Ribble Valley Borough Council  
Development Control

Application no: 3/2020/1011

Address: Rimington Caravan Park, Hardacre Lane, Rimington

Proposal: Extension to existing caravan site (62 additional pitches)

SK-S-100A

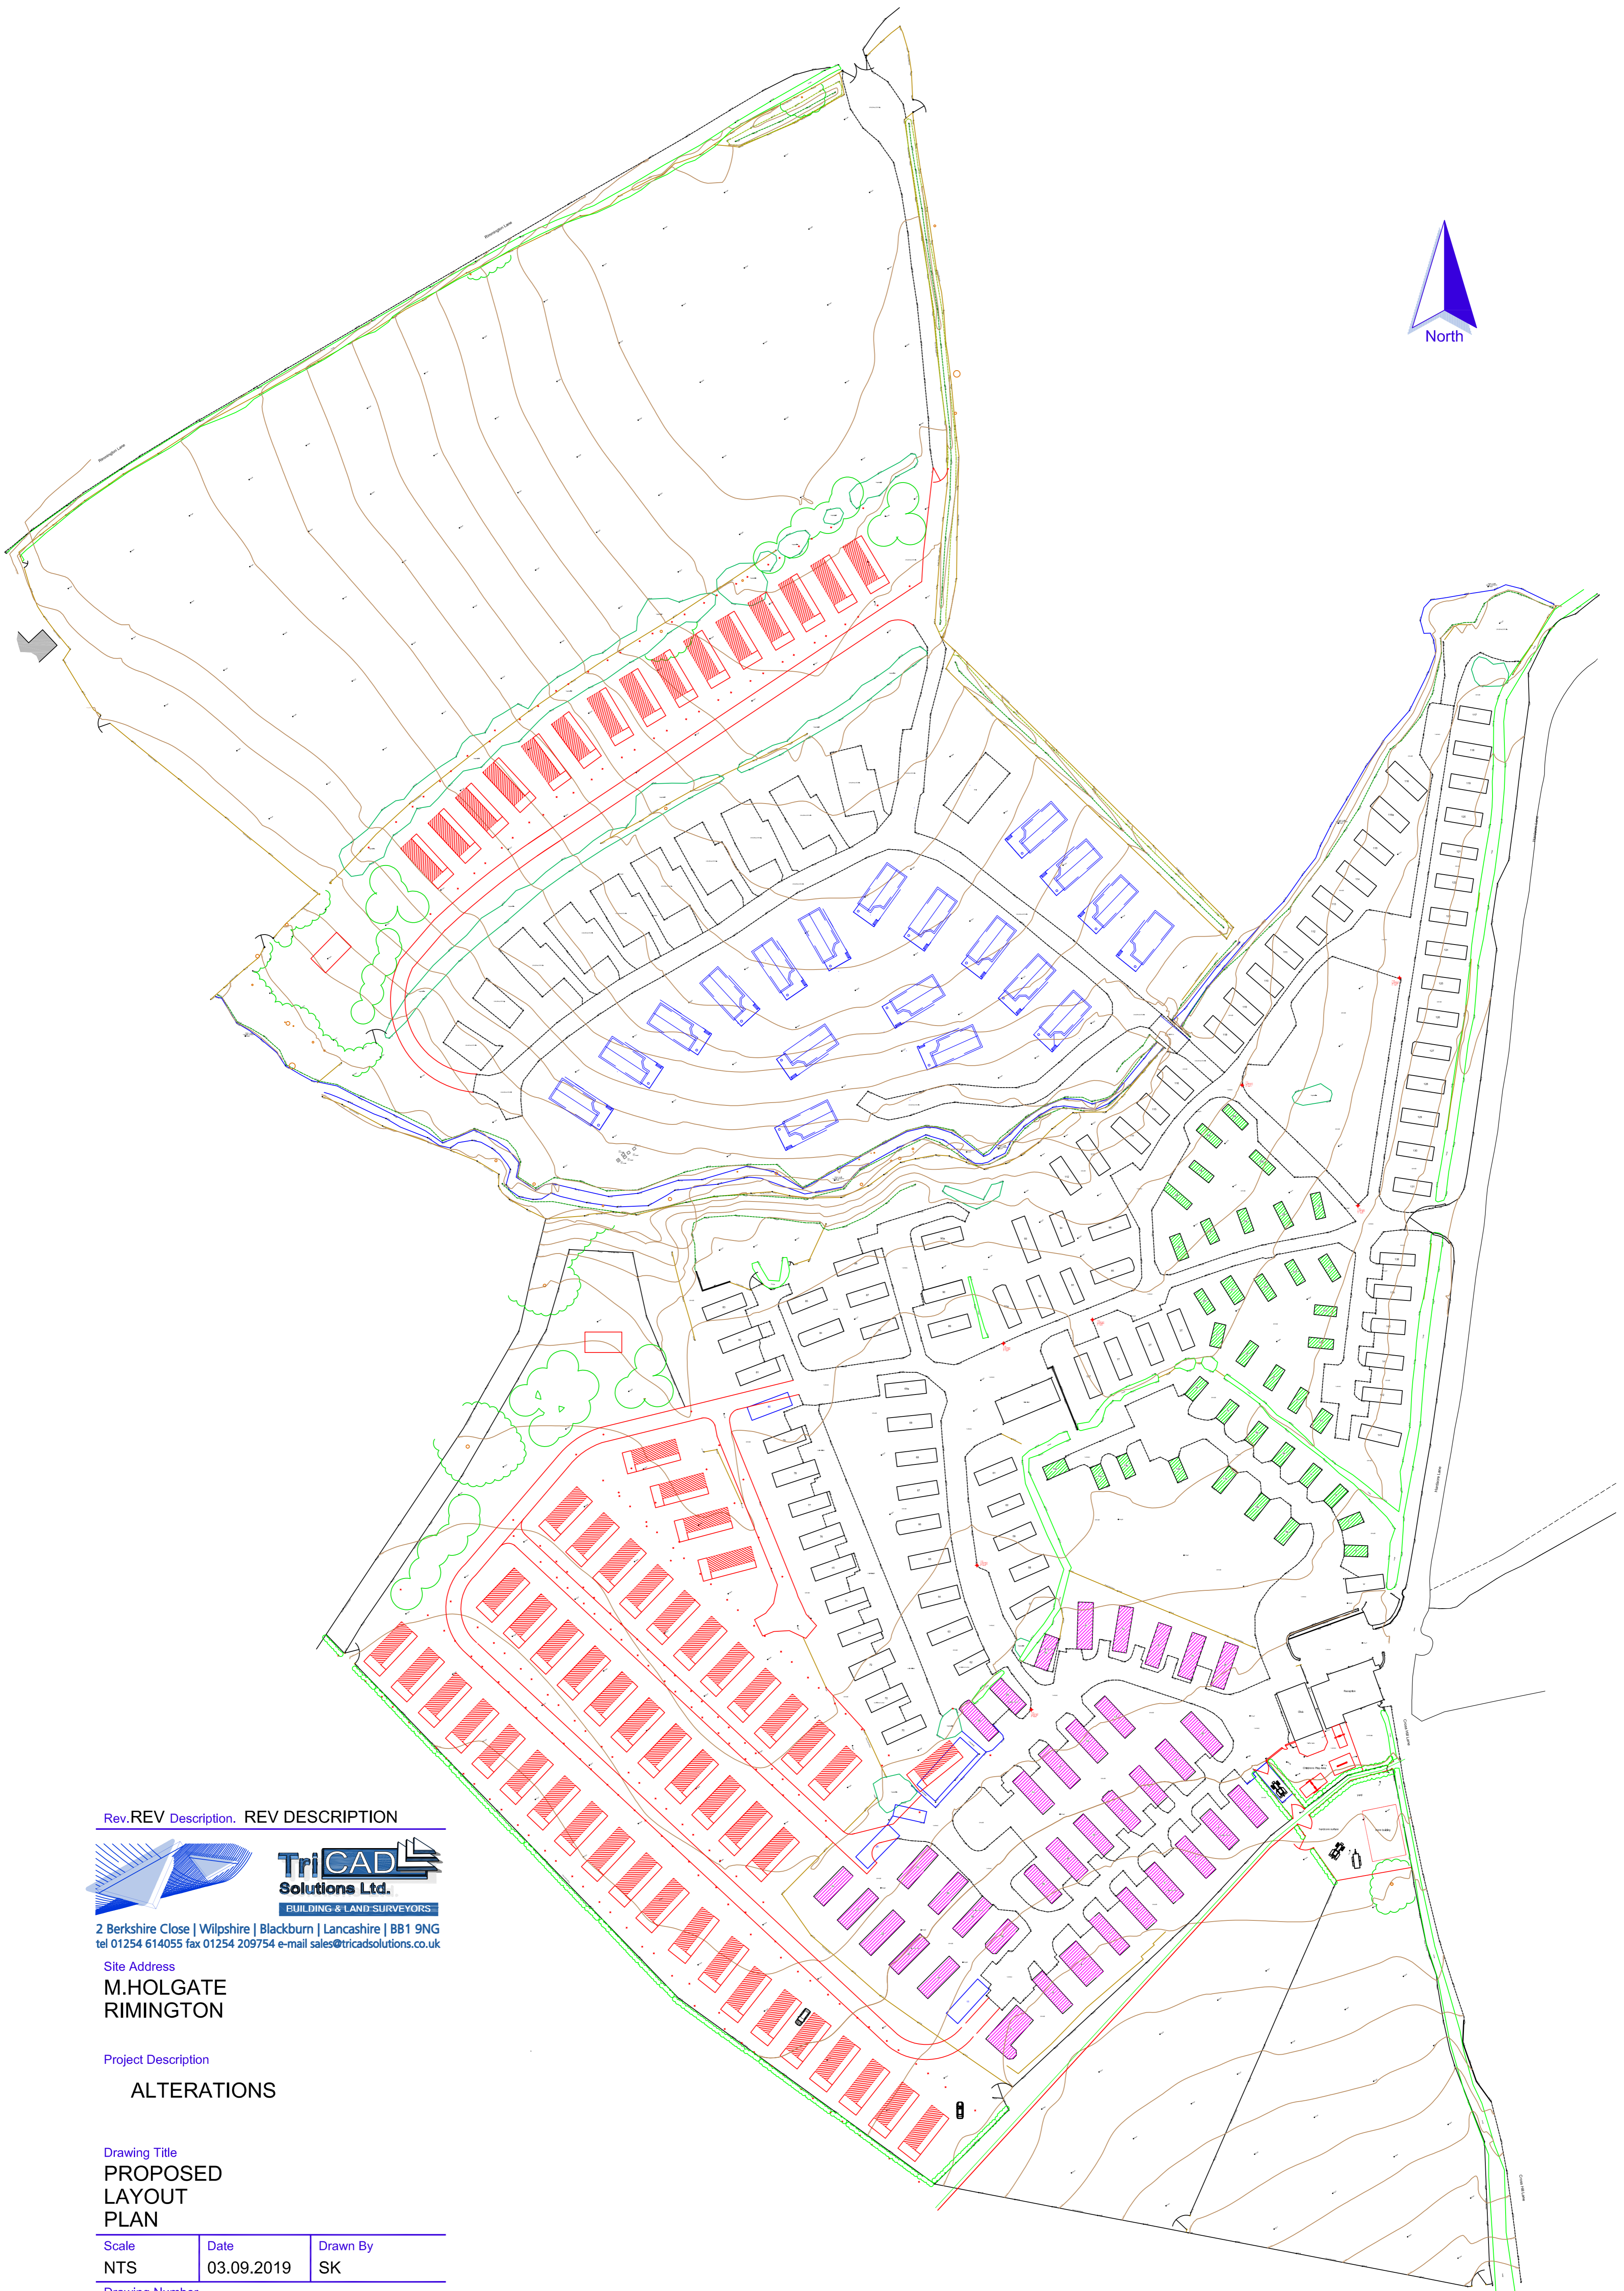
The proposal is for an extension to an existing caravan park and comprises of an additional; 62 pitches being accommodated on site. A TRICS analysis has been undertaken to determine the likely traffic generation from the site and this would be in the region of 4 additional vehicles in the am peak and 16 vehicles in the pm peak. . There have been no recorded injury collisions on the local road network and on this basis I would raise no objection to the proposal on highway grounds. However it is noted that as part of the development a link is to be created from within the site to a new build storage building and compound. This link crosses a public right of way (PROW 3-36FP4) and it will be necessary to ensure that there is sufficient intervisibility between vehicles on the link road and pedestrians using the PROW. The submitted plan indicates a new hedge planting scheme which if allowed to grow to a height greater than 1.0m would impede this intervisibility. Finally, on the issue of the link road, the point at which it crosses the PROW should be suitably surfaced to ensure that its integrity is maintained for the benefit of the PROW users

1 No development shall take place, including any works of demolition, until a construction method statement has been submitted to and approved in writing by the local planning authority. The approved statement shall be adhered to throughout the construction period. It shall provide for:

- ❖ The parking of vehicles of site operatives and visitors
- ❖ The loading and unloading of plant and materials
- ❖ The storage of plant and materials used in constructing the development
- ❖ The erection and maintenance of security hoarding
- ❖ Details of working hours
- ❖ Caravan delivery times and routeing to / from the site
- ❖ Contact details for the site manager
